re plans applied for no FG/135/17
objection for the 9th Apartment.

ARUN DISTRICT COUNCIL

Proposed Block Site Plan - 1:200 @ A1

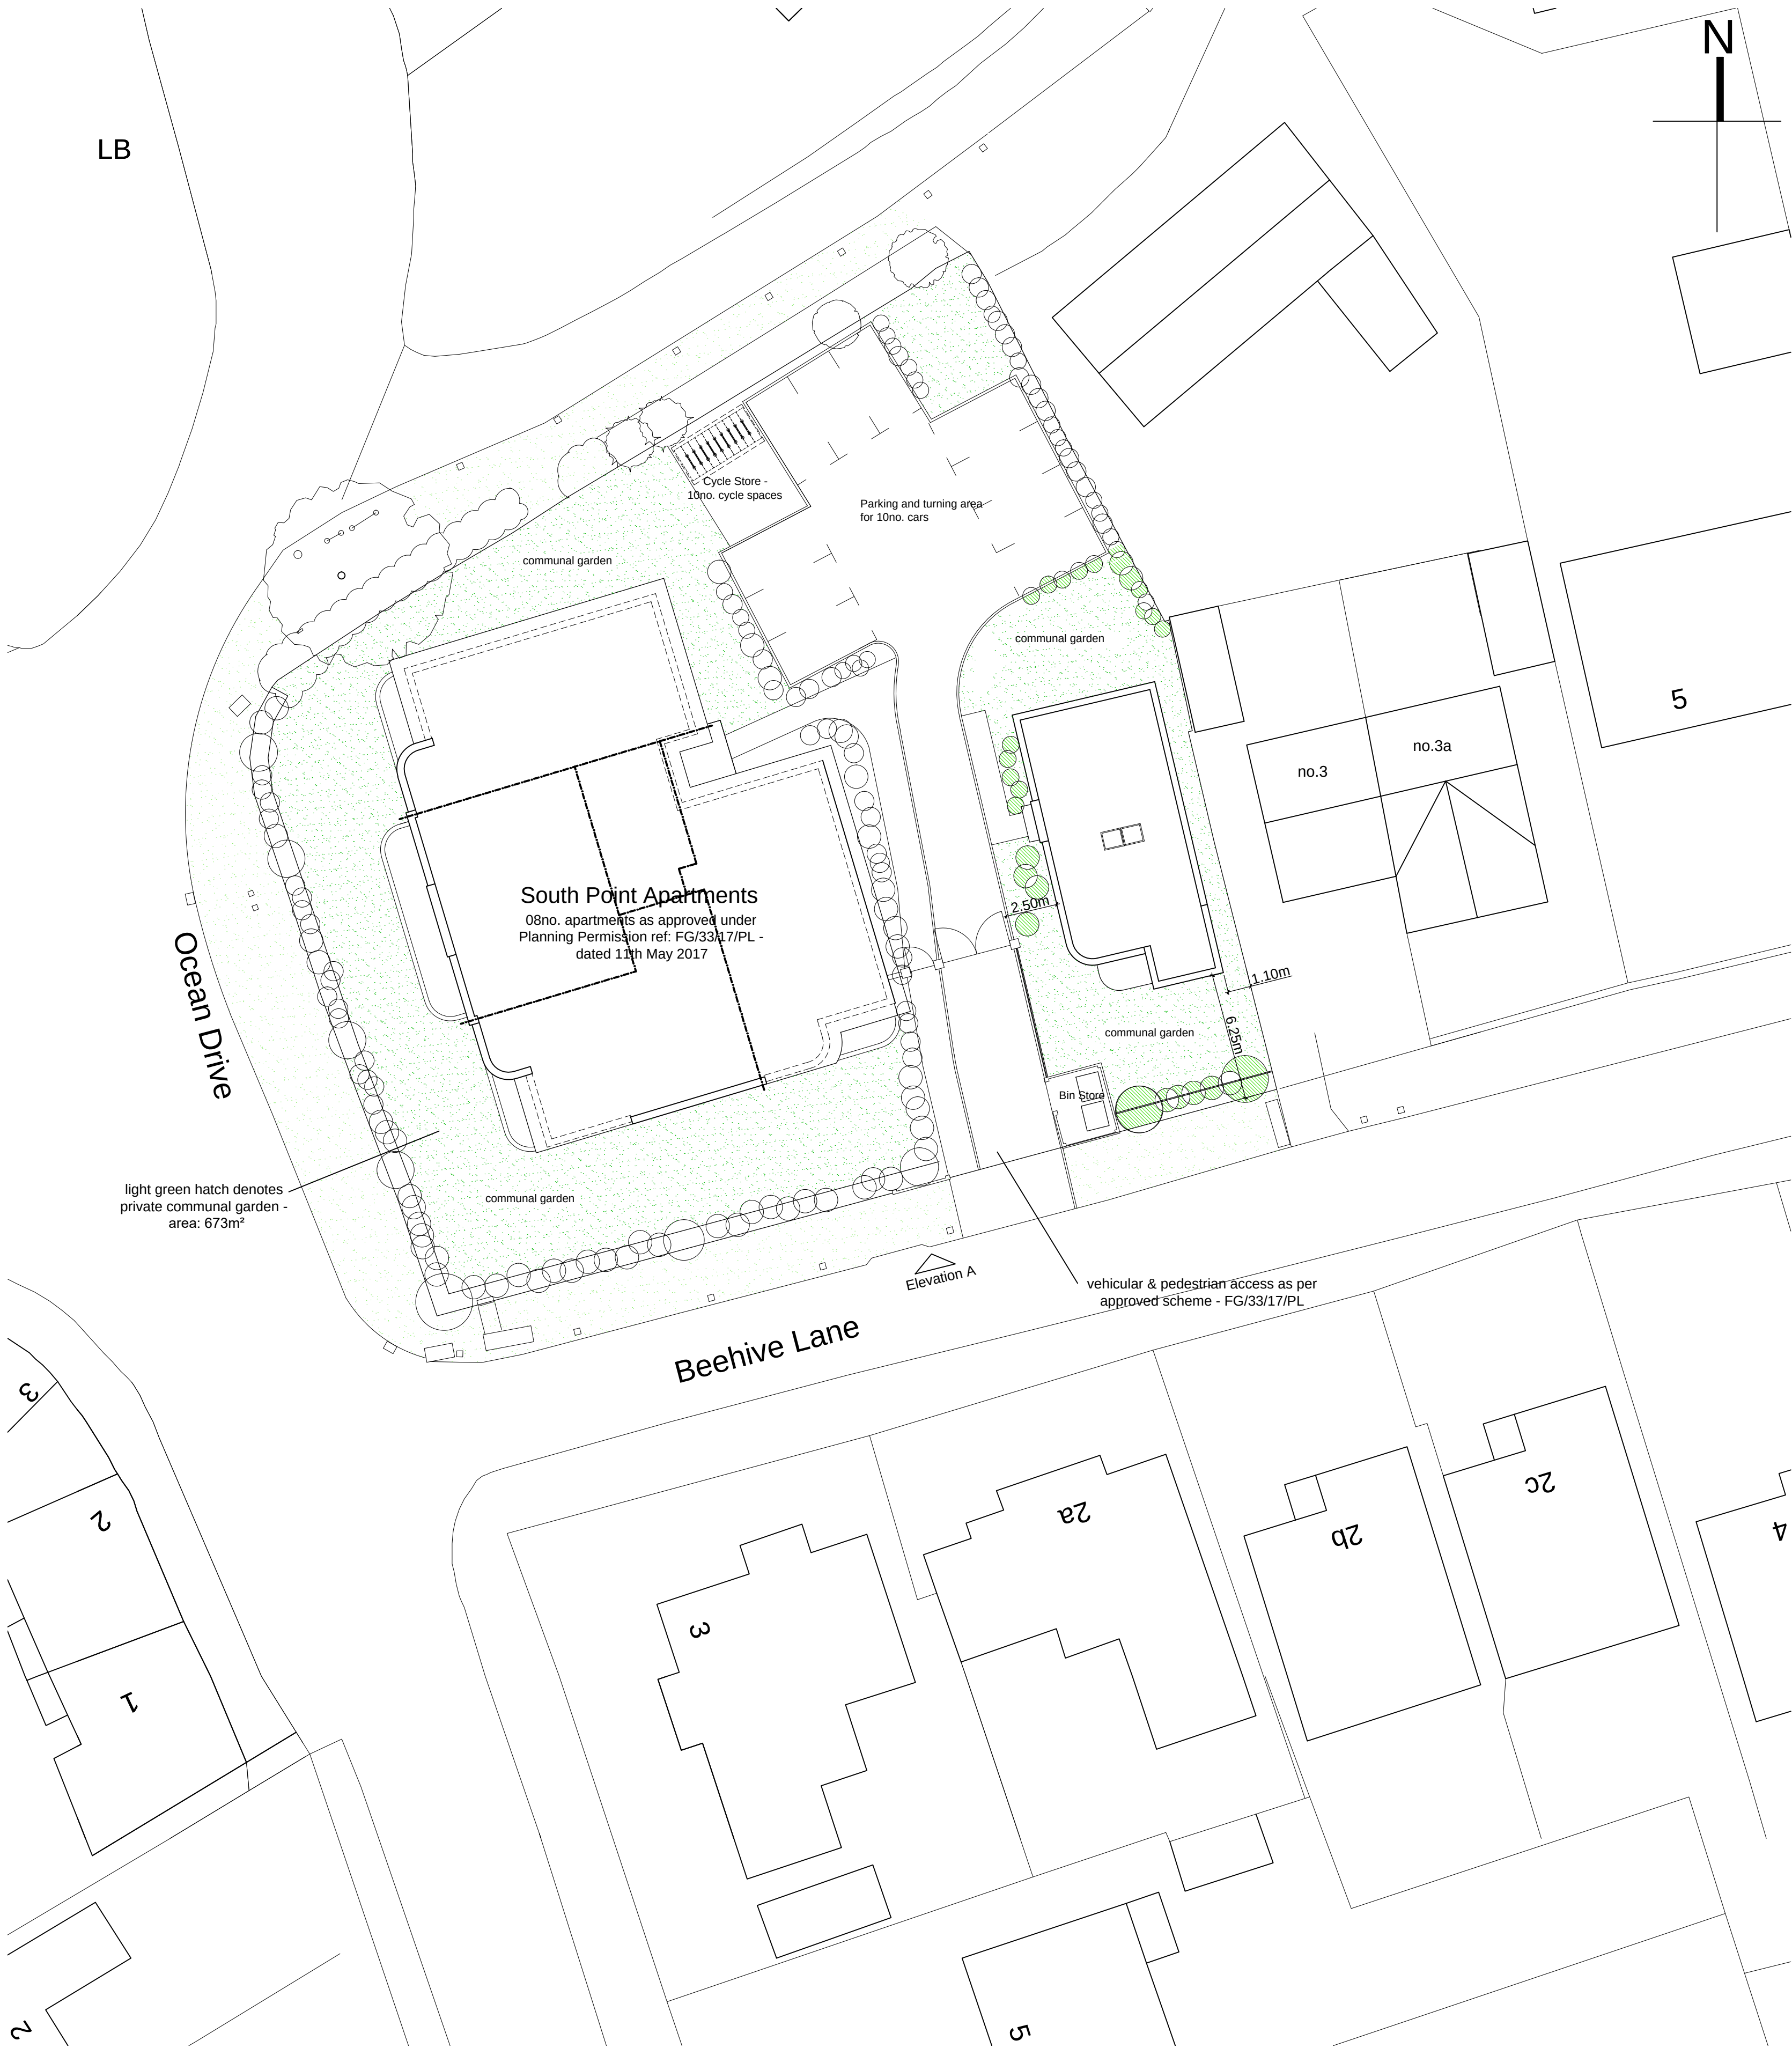
As already the whole of the building plot is looking well overdeveloped and totally unacceptable considering there was only one property originally sited there. The area the developers are wanting for the 9th plot is where the communal garden should be. Also it would be very close to the boundary and the existing bungalows in Beehive Lane. As we have lived in Ferring next to the plot we personally knew the owners of the original thatched house and accepted one day there may be 4 bungalows permitted what a shame. Globe Estate managed to change the original plan. Finally the said new Plans would completely overdevelop the plot on the very busy corner

and already is showing signs of traffic
problems on the corner of Beehive Lane and
Ocean Drive especially in school term when
many children walk or cycle to the local school
and already I see many accidents waiting
to happen even before the extra ten to twenty
vehicles using the plot
